ASSESSMENT REPORT

Commercial and Retail Development – Mount Street, North Sydney MP 08_0241 MOD 5

This report is an assessment of a request to modify the Concept Approval MP08_0241 for a commercial and retail development at 86-96 and 100 Mount Street, North Sydney.

Plan - Ground Floor

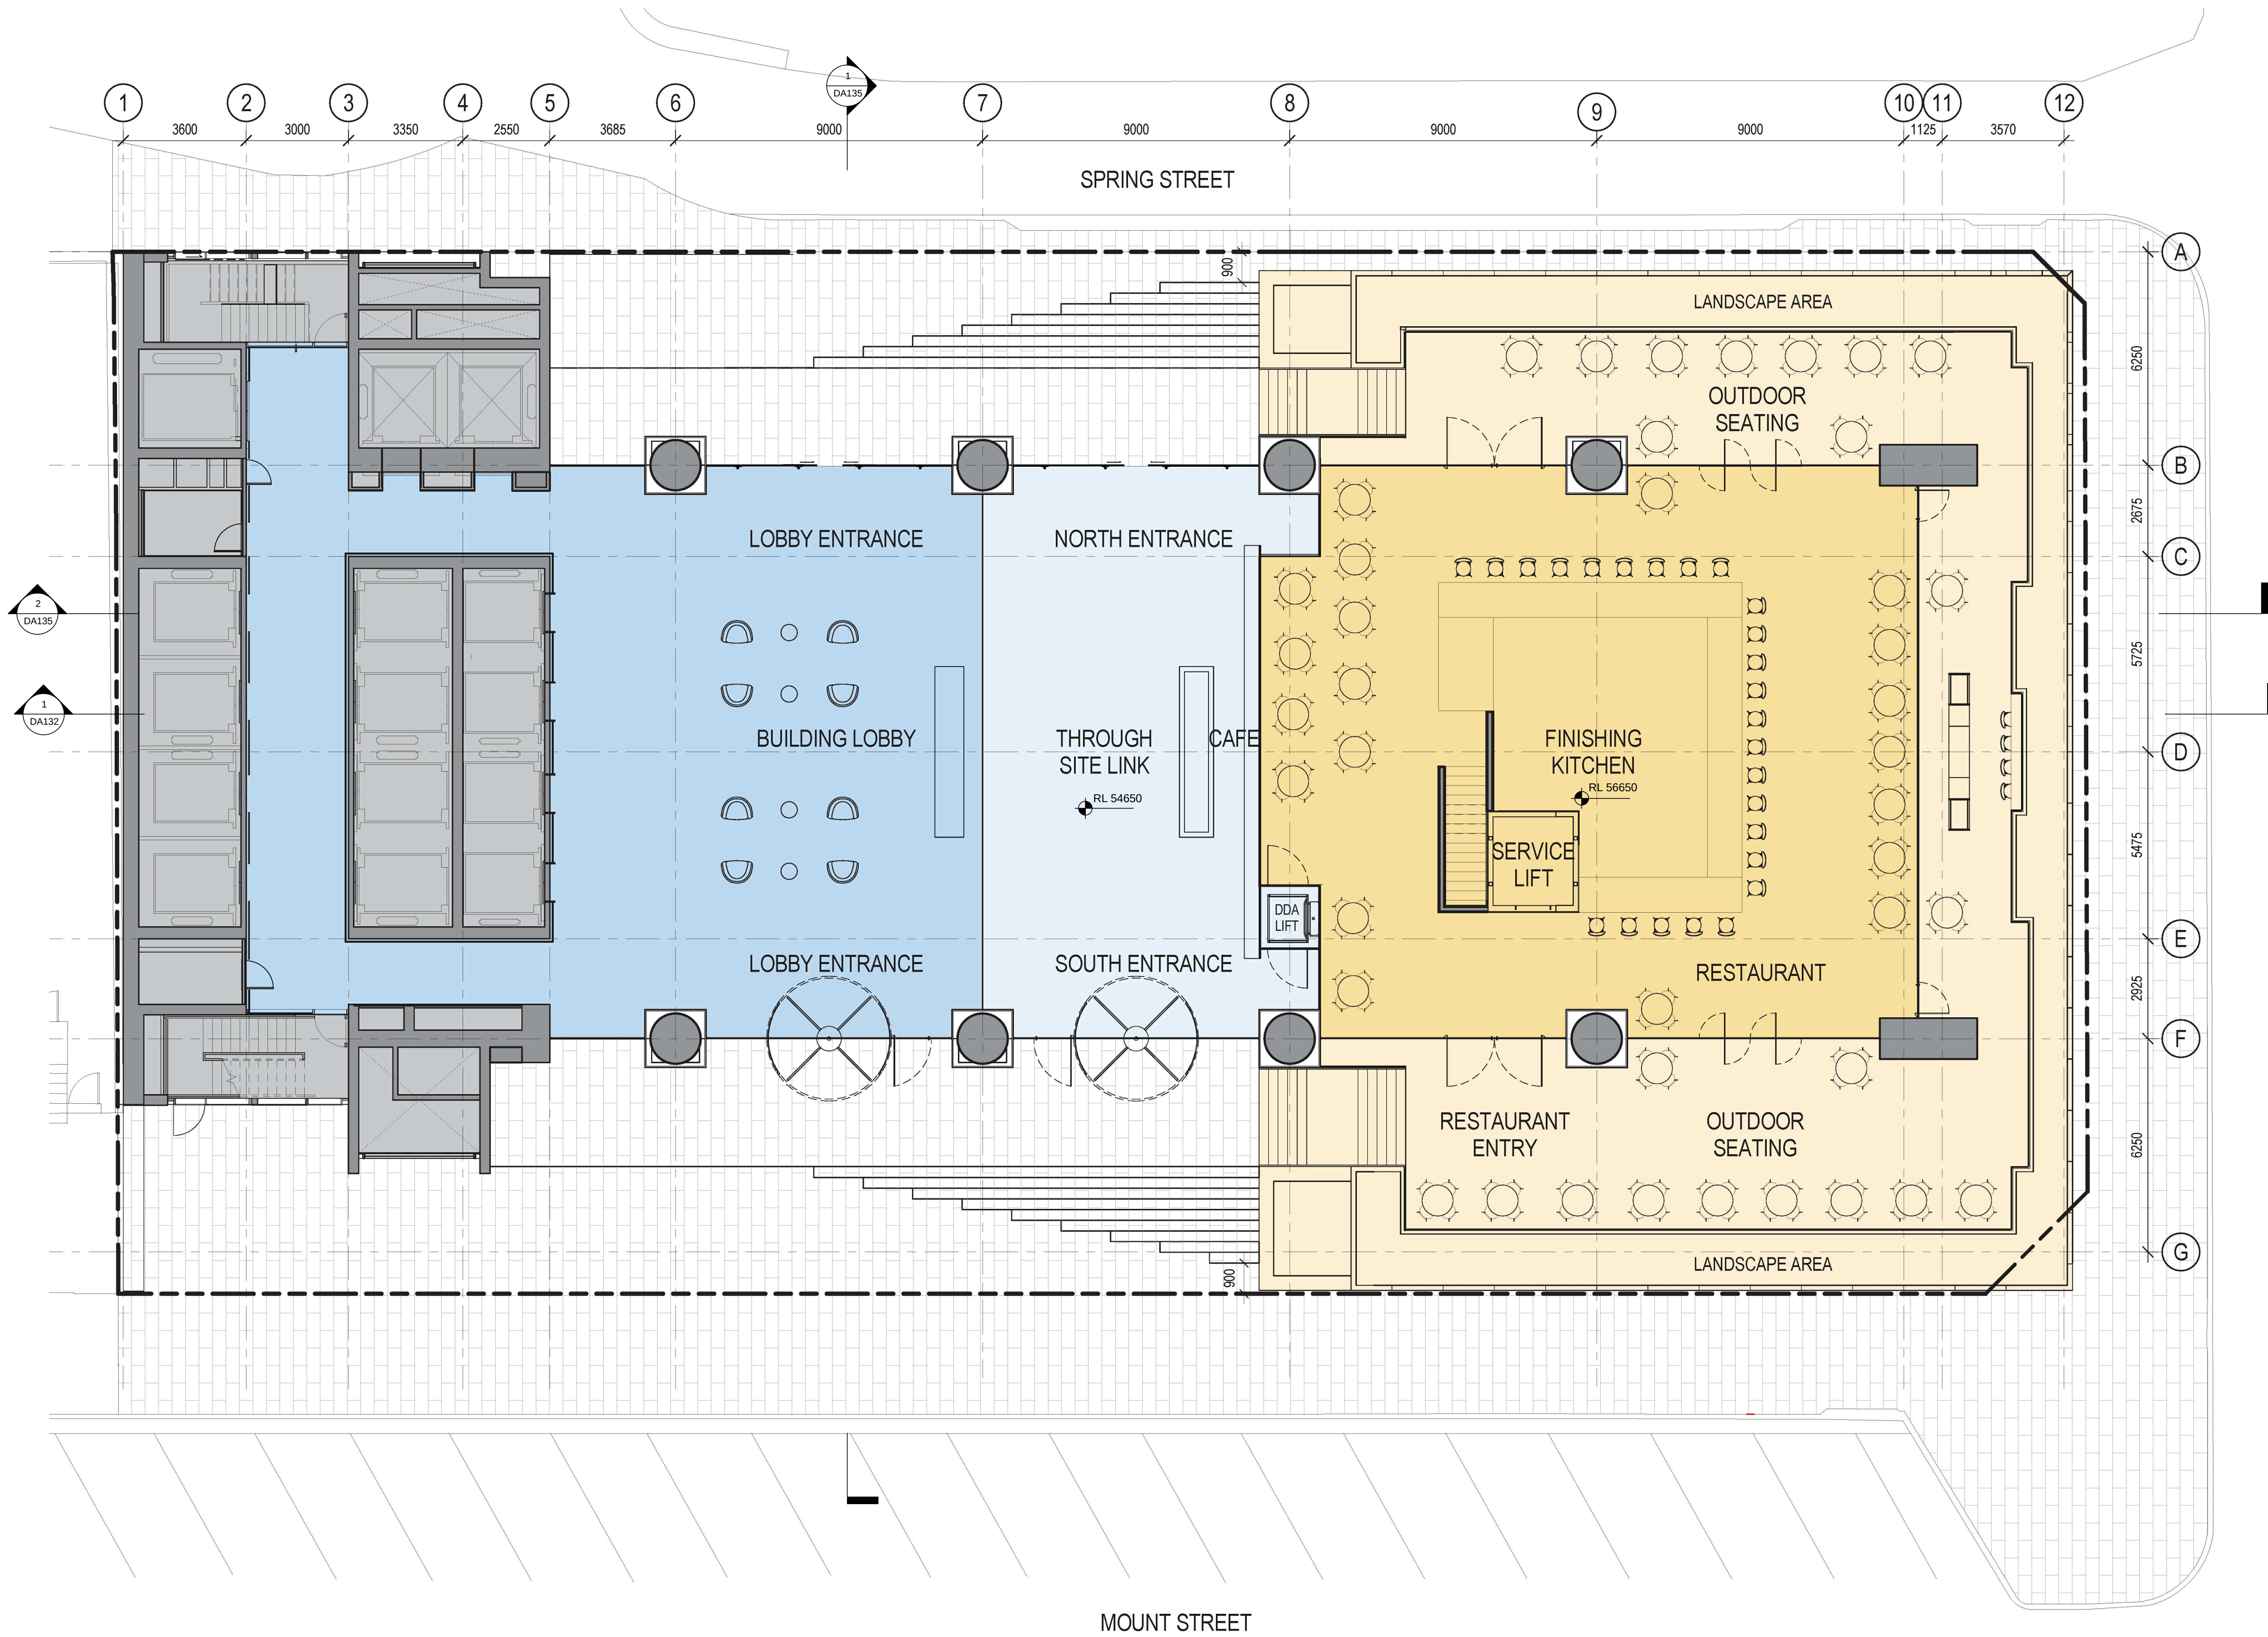
- enlargement of the ground floor level restaurant (and outdoor seating area) and lower ground level retail tenancy by extending the footprint to the Mount Street Boundary;
- provision of new plant room at level 1 and corresponding reduction of office accommodation at this level; and
- enlargement of level 1 mezzanine floorplate, rename as 'level 2', convert use of level from plant to office space.

- the additional GFA is minor, localised at ground and second floor levels, and does not significantly change the overall bulk and scale of the approved development;
- the extension of the ground levels to the Mount Street boundary is consistent with Council's DCP, which recommends a nil setback for building podiums;
- the revisions to the elevations maintain a high standard of design and appearance;
- there would be no significant amenity impacts on surrounding properties; and
- the additional office and retail floor space positively contributes to the growth of North Sydney's CBD as a commercial centre.

Roof Sections

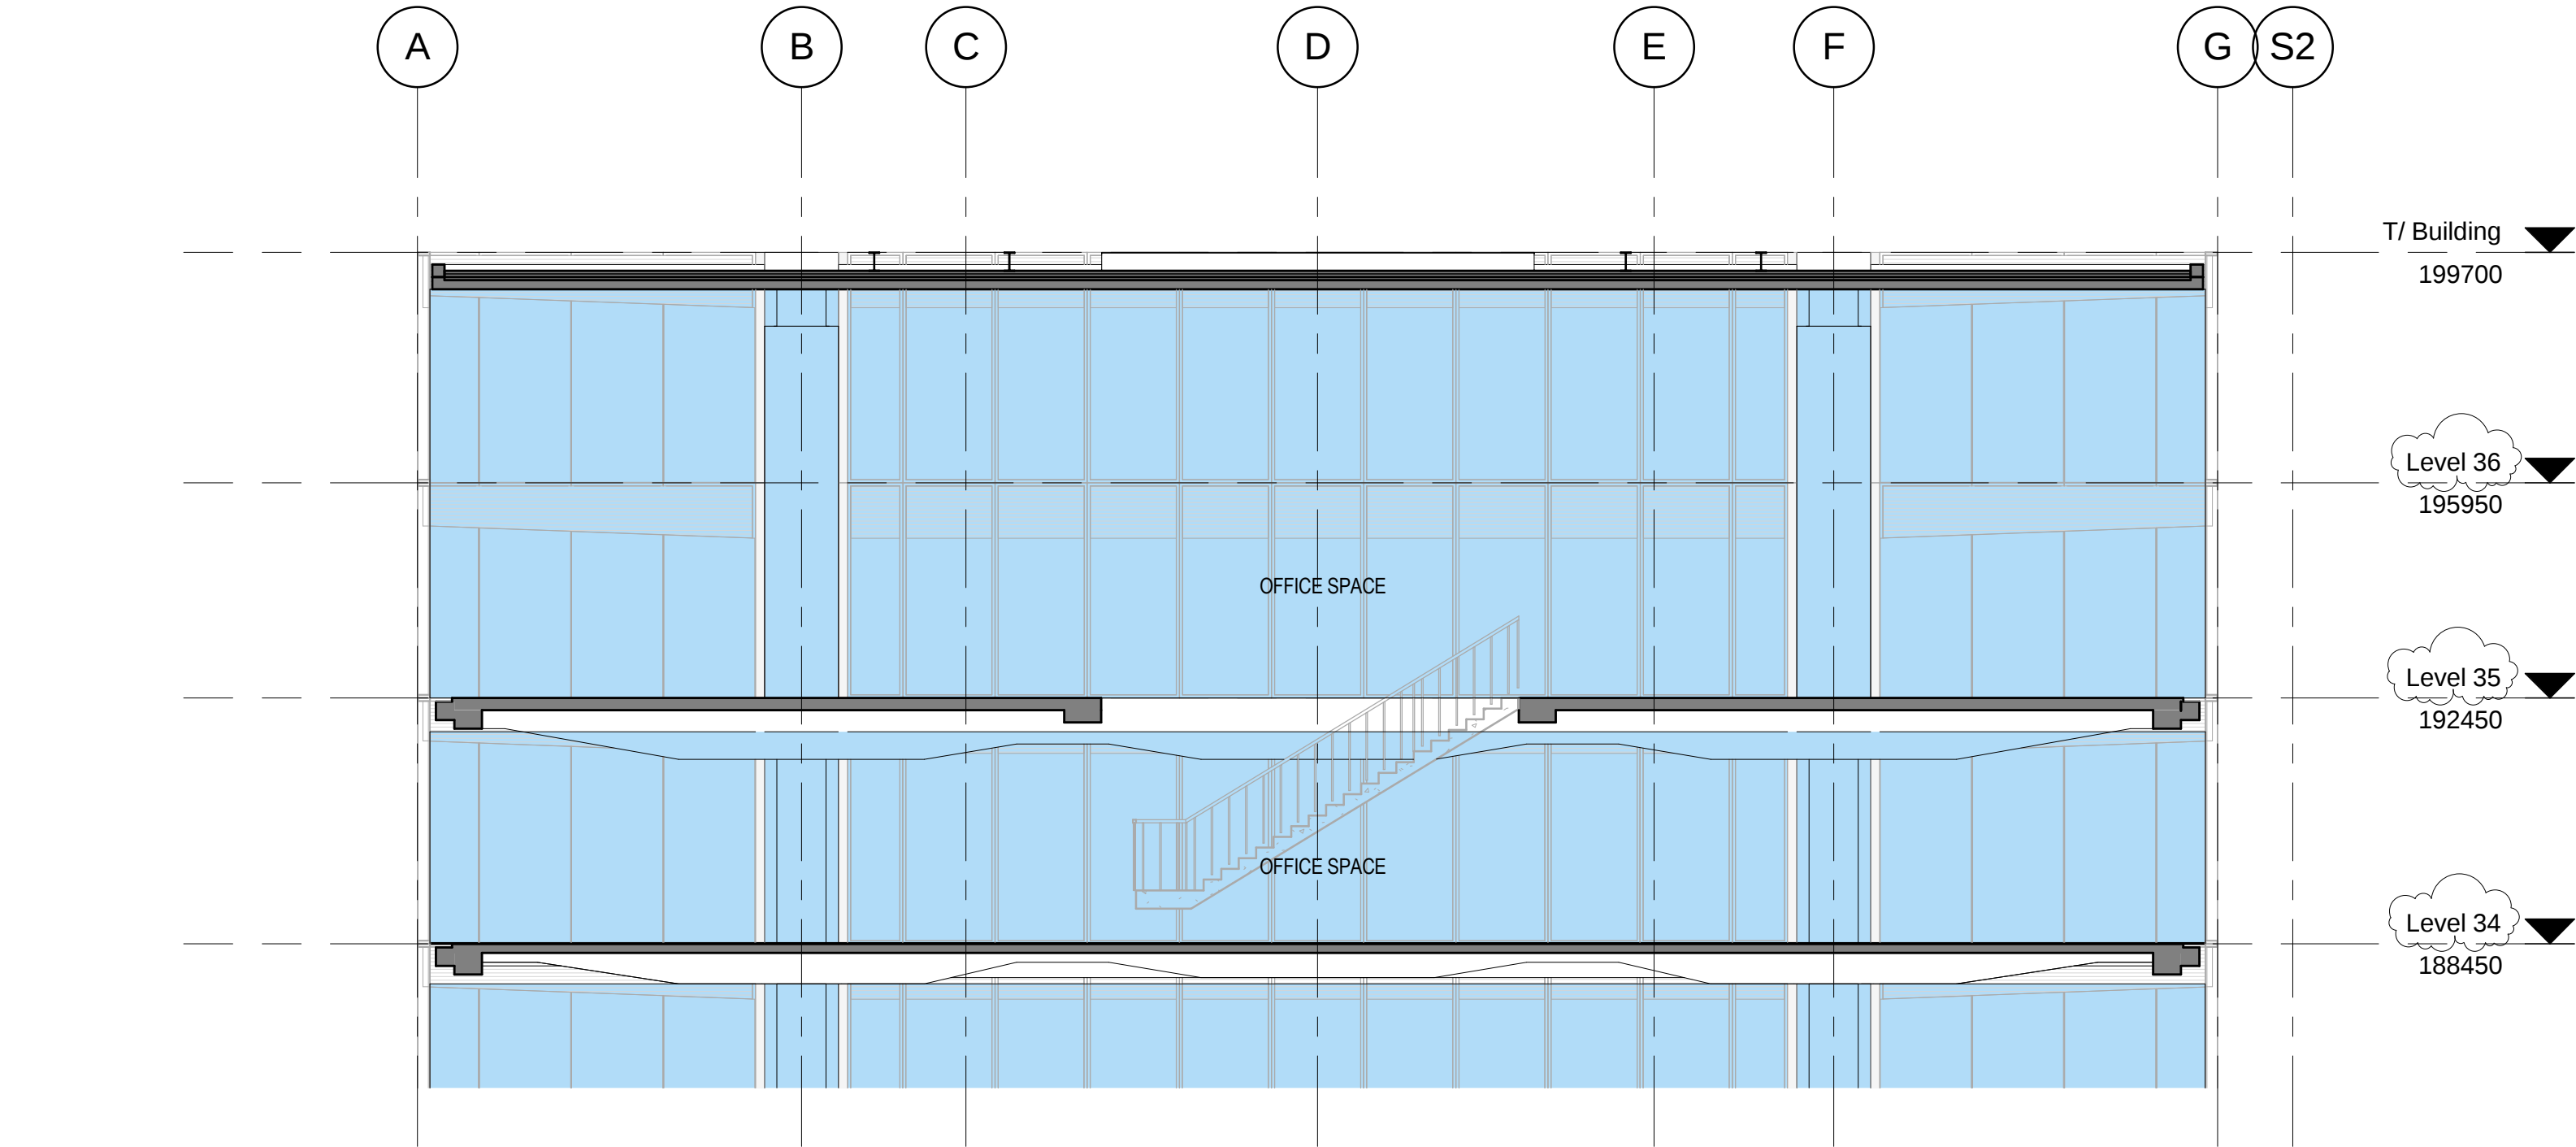
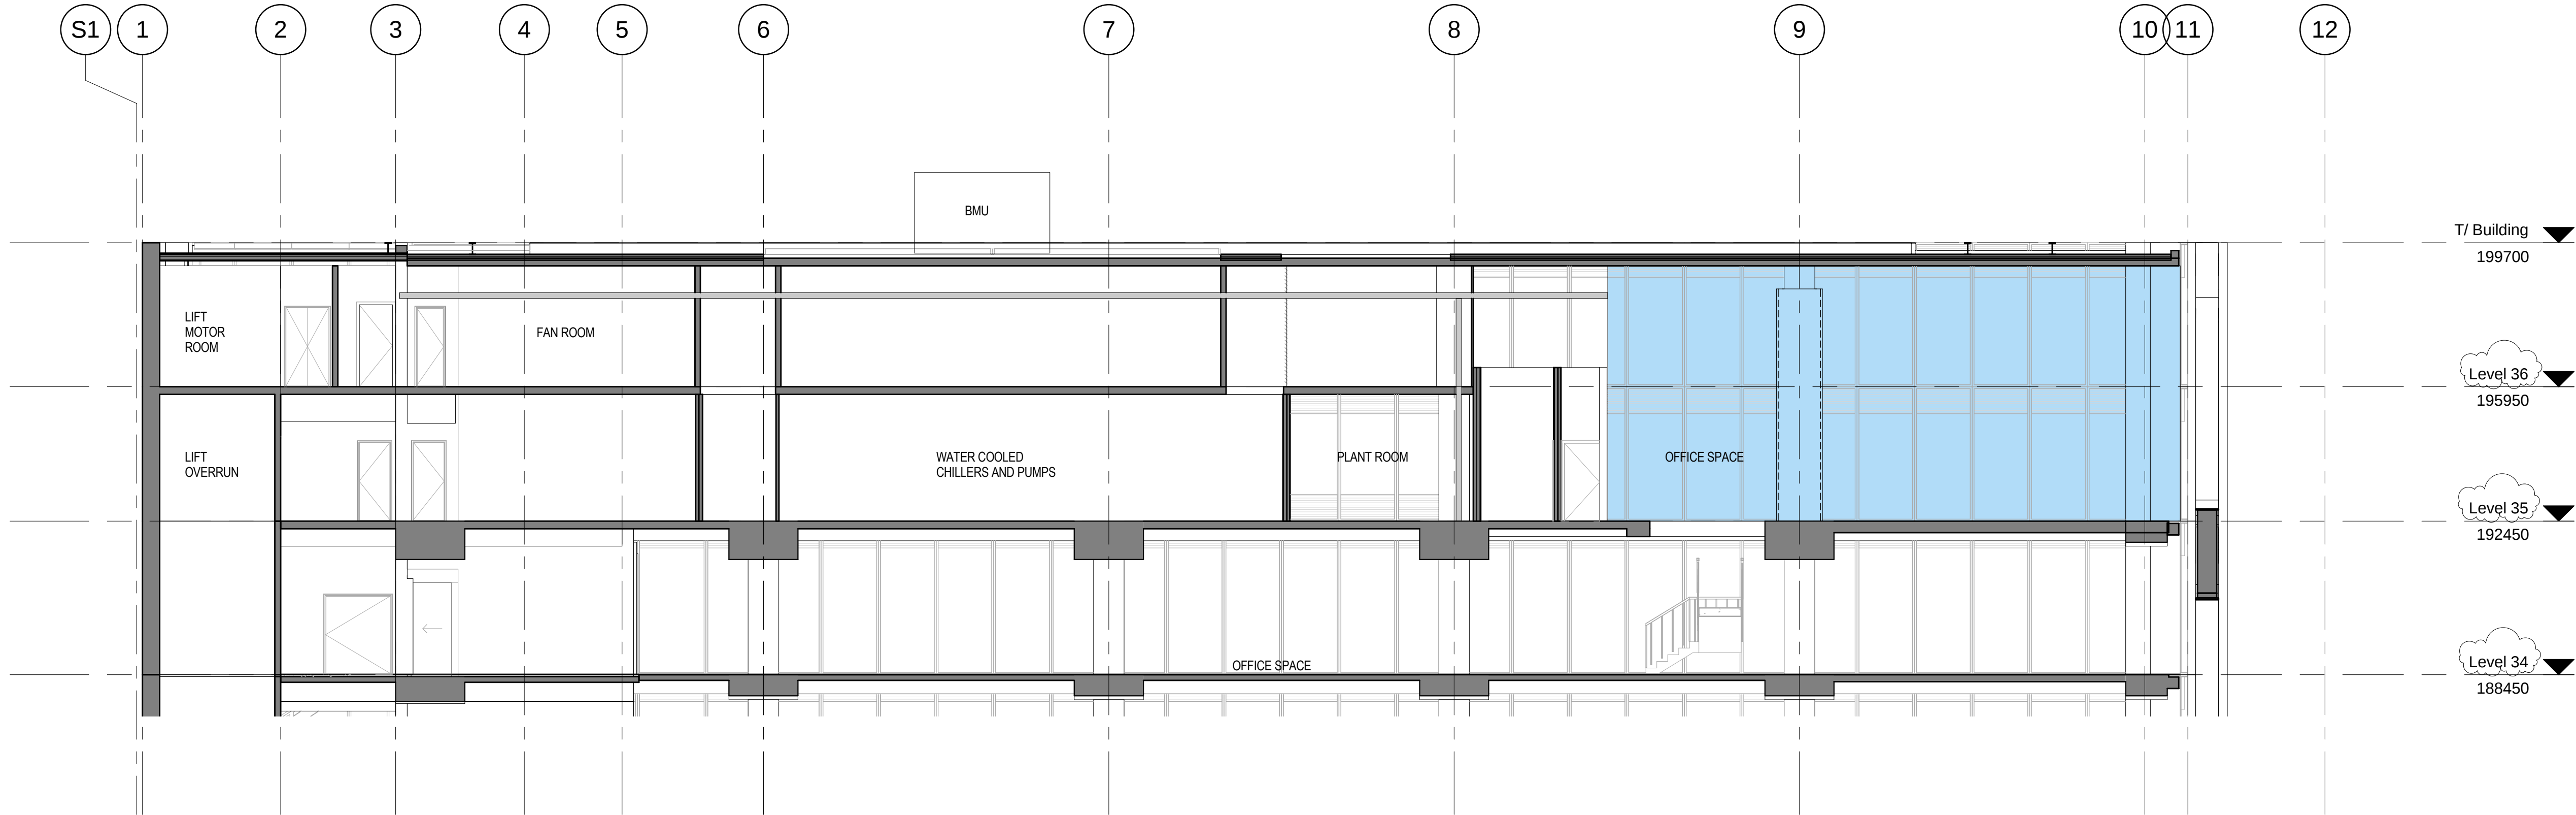
Issue	Consideration	Recommendation
<i>Increase in height</i>	- The modification includes an increase in the height of the roof level to match the height of the external parapets (refer to Figure 4). This also results in a corresponding increase in the height of the building maintenance unit (BMU) above the overall building height (from RL 199.70 to RL203.1). - Although the proposal exceeds the maximum height control of RL 195 applicable to the site under <i>North Sydney Local Environmental Plan 2013</i>, the Department considers the proposed increase is minor and acceptable as: - the increased roof height would be entirely screened behind the approved parapet line; - the BMU is centrally located within the roof and would not be visible from the surrounding streets or public domain; - the modification would not result in adverse overshadowing or view loss impacts; and - Sydney Airport has not raised any objection to the minor increase in height and has approved the penetration into the prescribed airspace.	No additional comments or amendments necessary.
